VERIZON SITE NUMBER:  
**171393**

BU #: 877090  
FILL-IN/ COLORADO SPGS/  
CSP154

SHEET NUMBER: **C-1** REVISION: **1**

PCD File No. COM-22-024

SHEET NUMBER: **C-1** REVISION: **1**

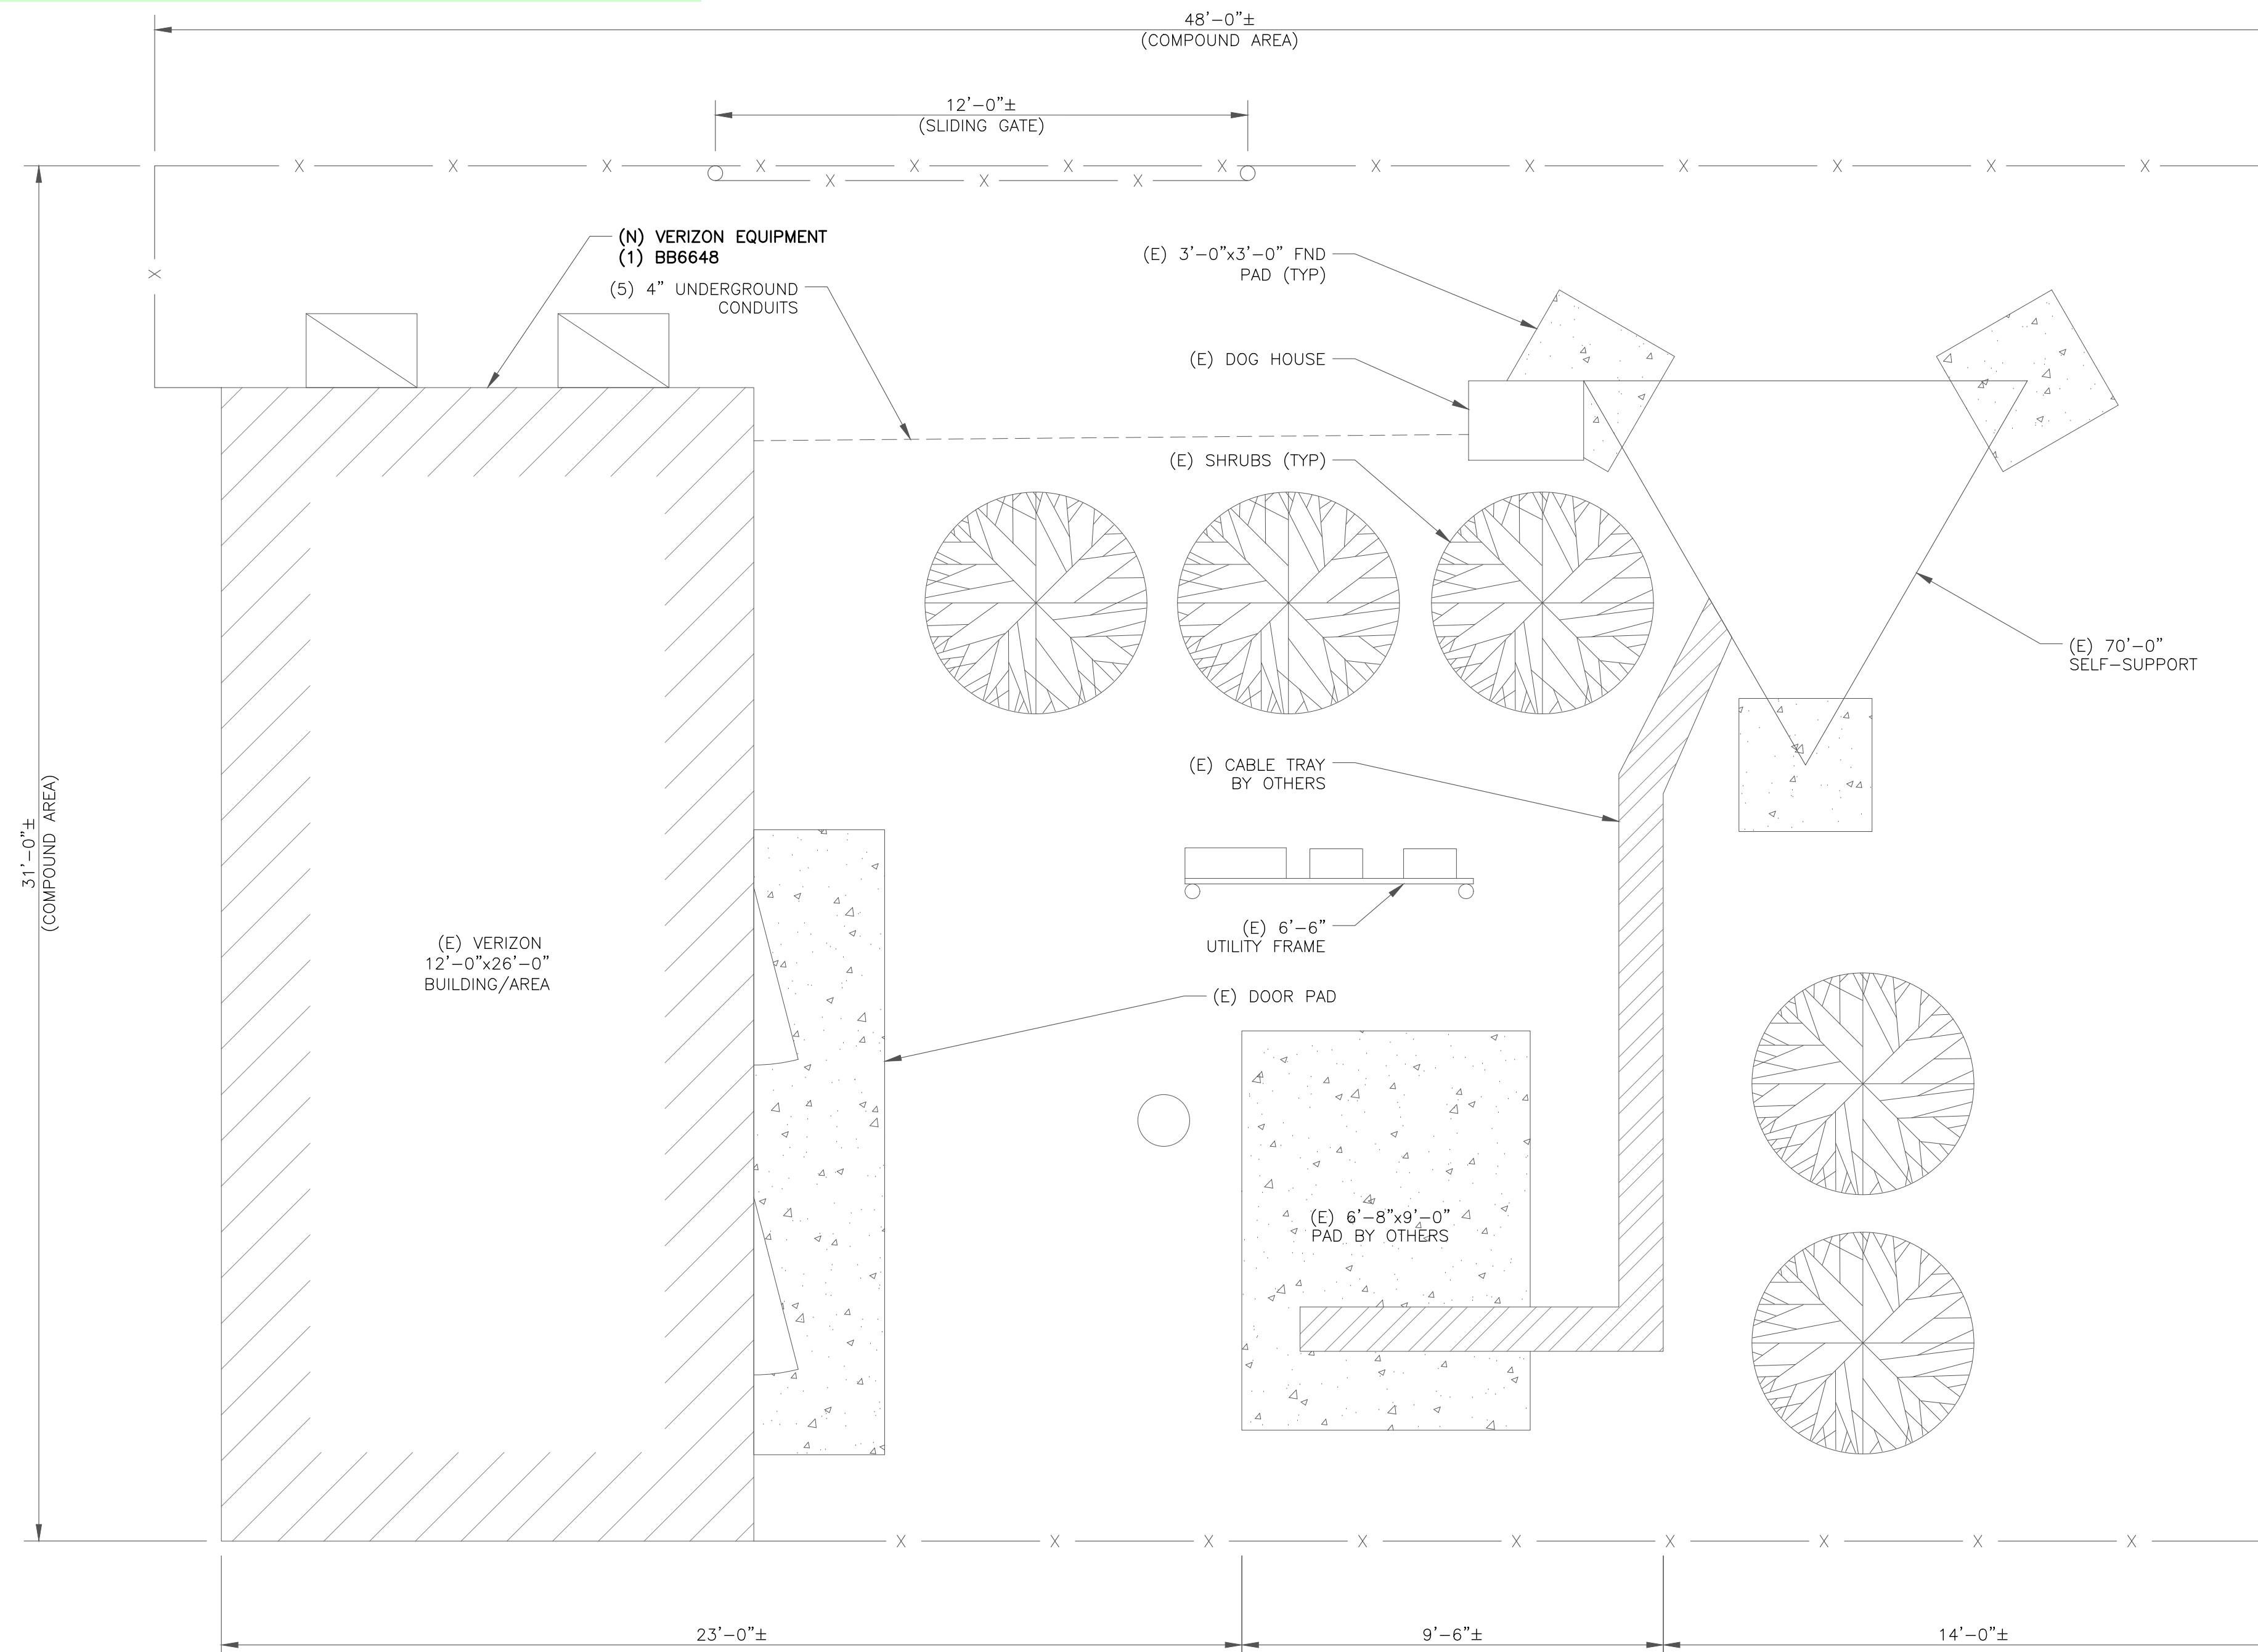
Please include:  
-vicinity map showing the subdivision in relation to section lines and existing or proposed arterial or collector roadways  
-location and dimension property lines, rights of ways, and all existing and proposed easements  
-signature block for PCD, 1-2 inches  
-setback distances from each existing and proposed structure to the property lines
